Application No: AL/22/25/HH

Site Address: 28 Church Road Aldingbourne PO20 3TT

Description of works: Replacement single storey rear extension. New side facing dormer window and rooflight at first floor level. (This application may affect the character and appearance of the Church Road, Aldingbourne Conservation Area).

DWG NO 1407/04
REV B

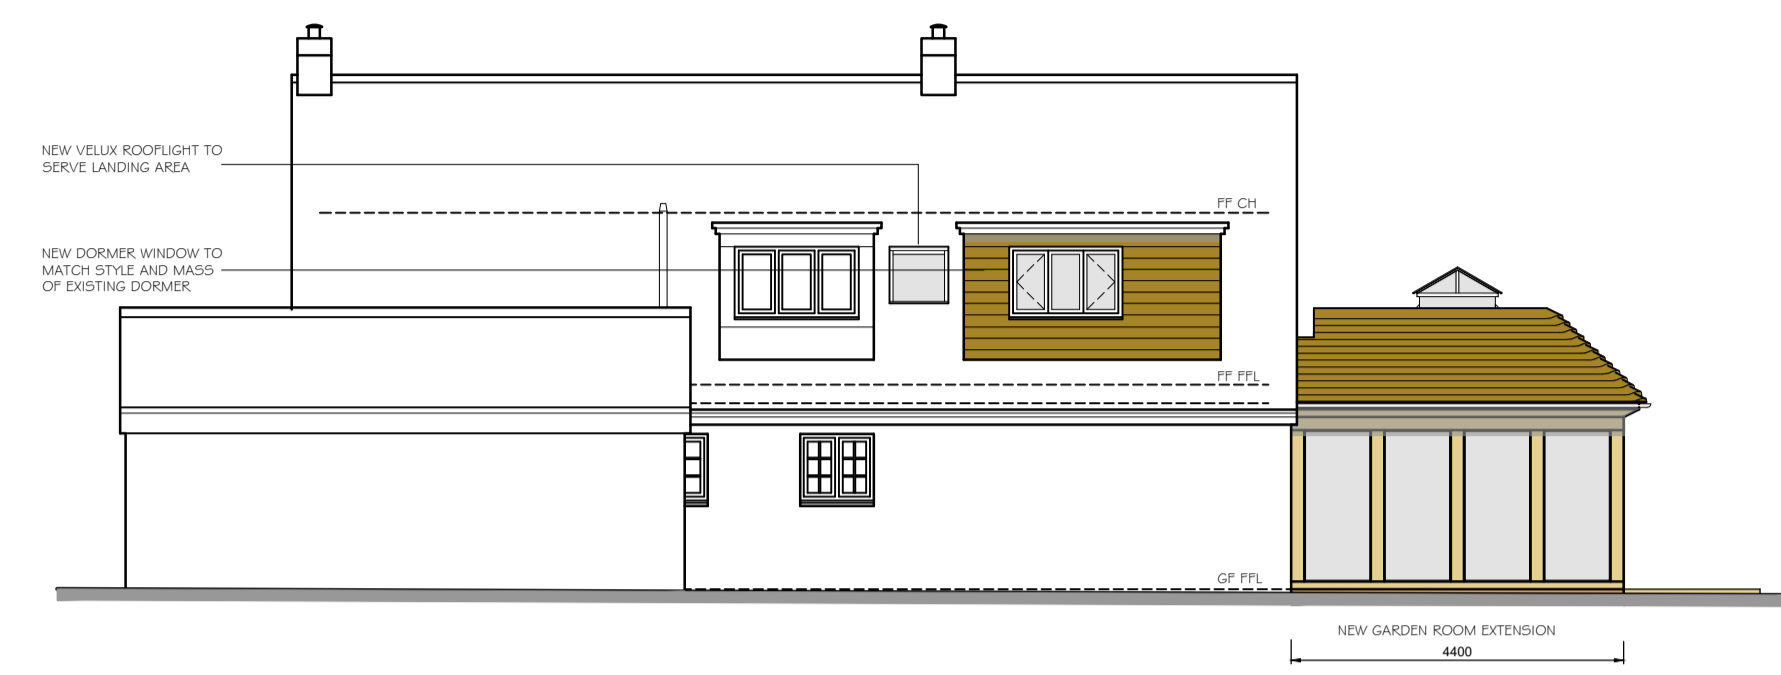
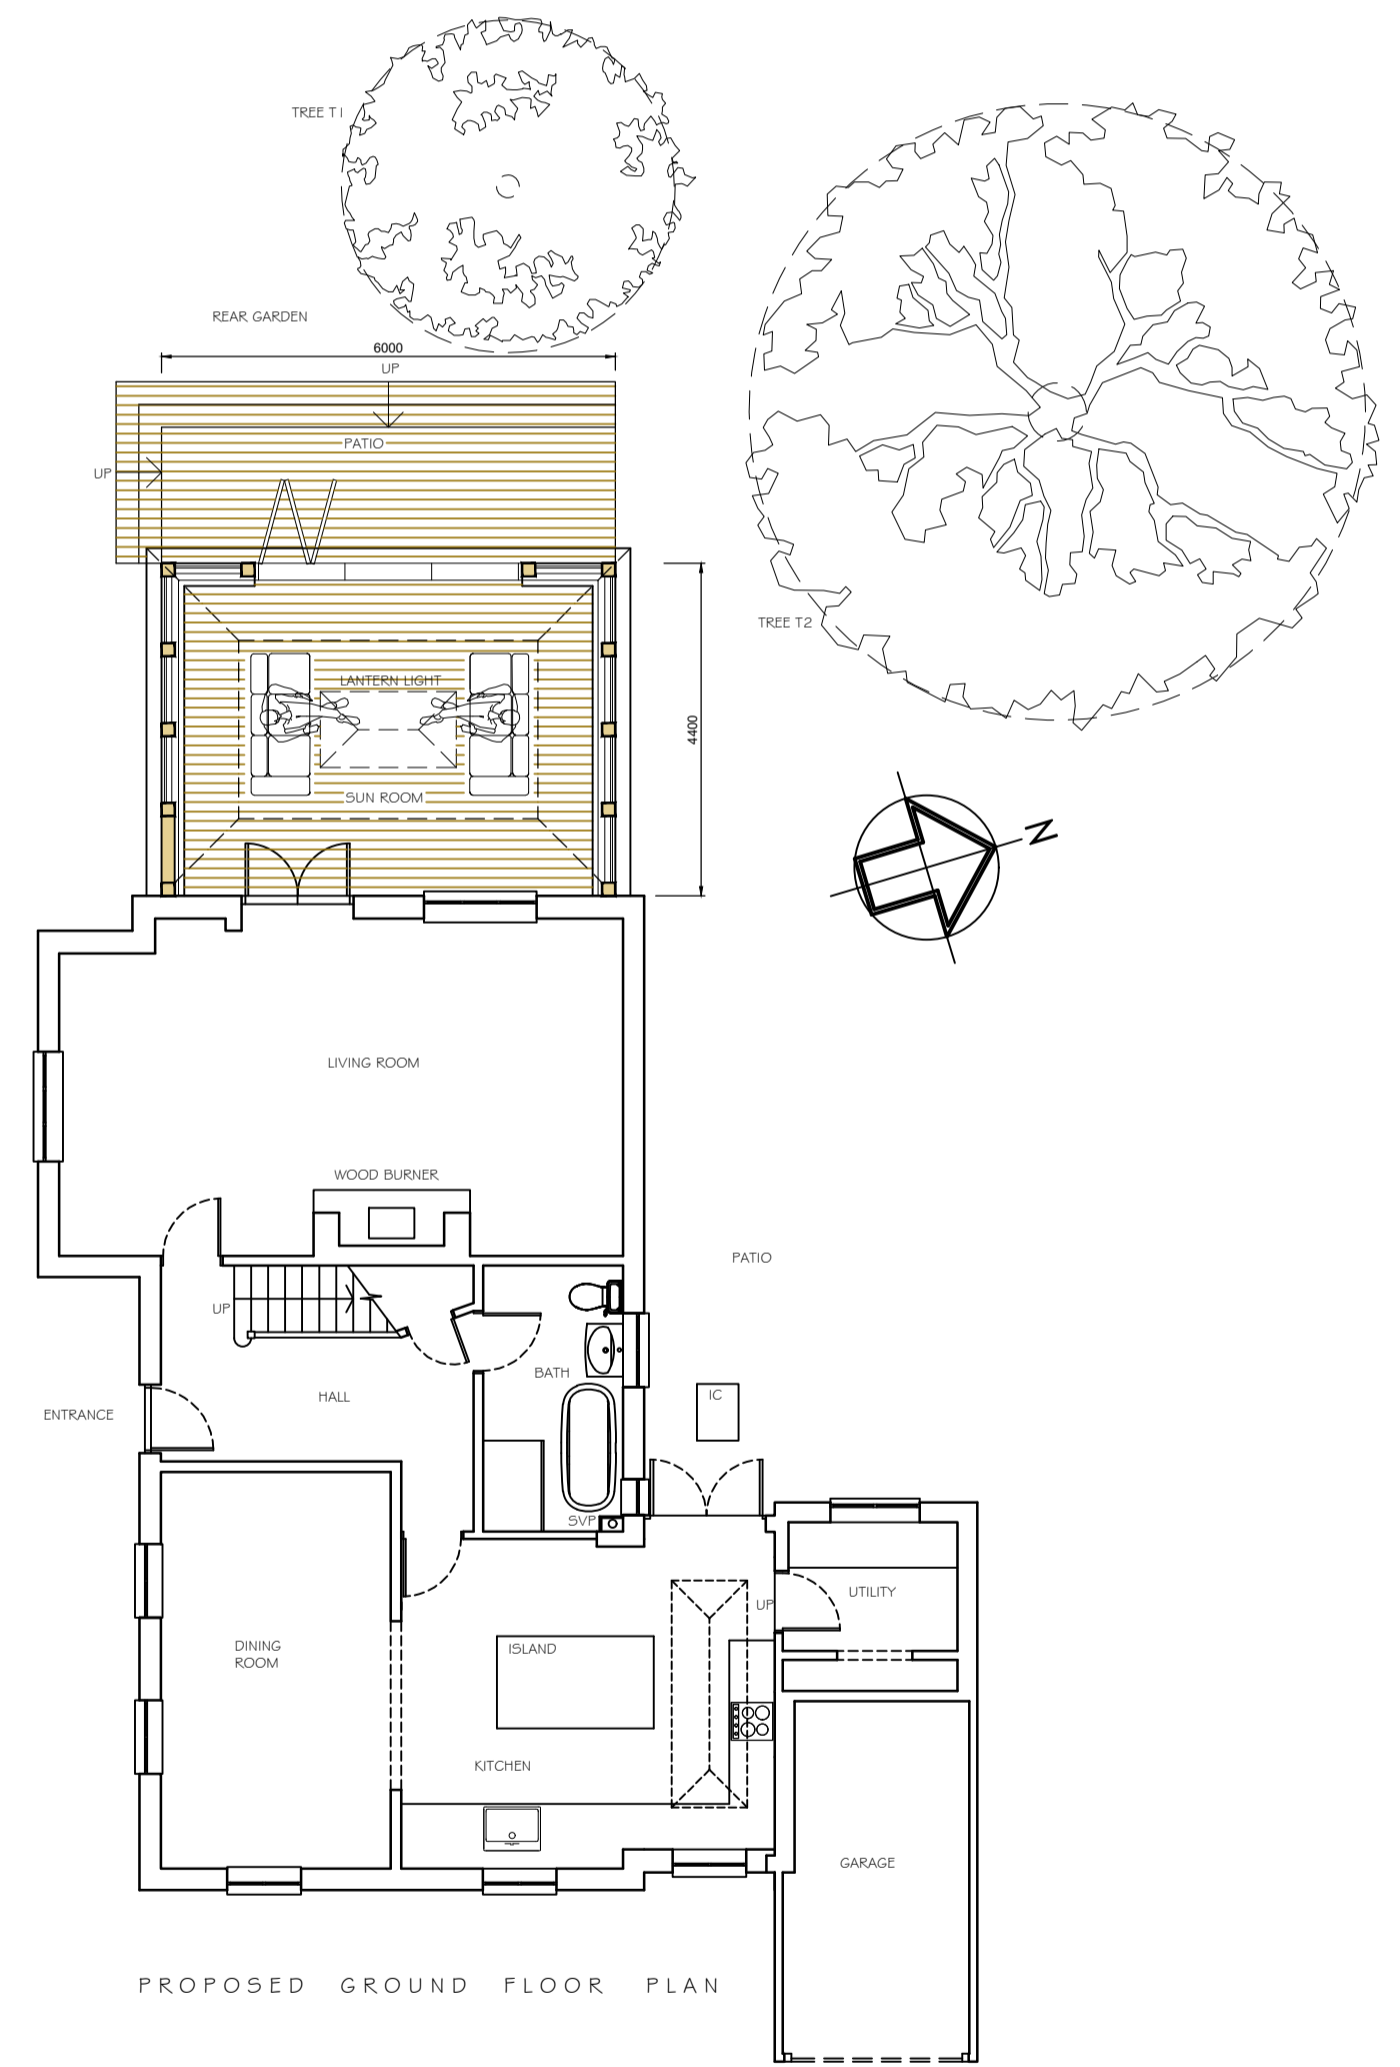
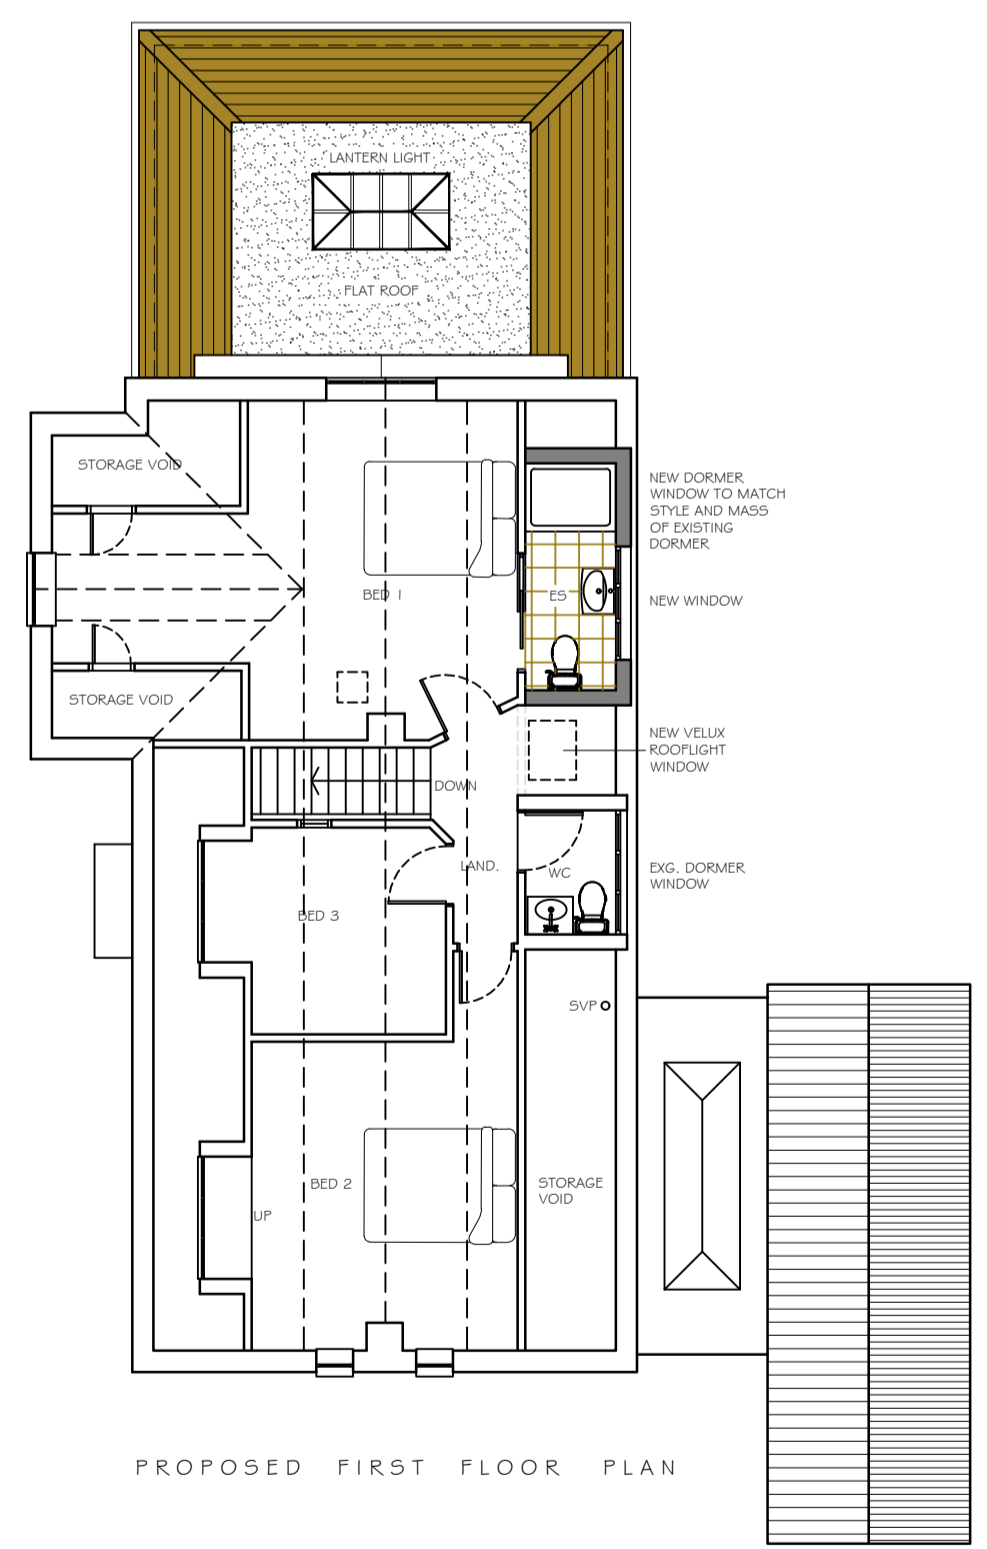
The parish council has no objection to this application but would ask that consideration is given to the Dark Skies Policy EH10 of the Aldingbourne Neighbourhood Plan when looking at the window and rooflight options.
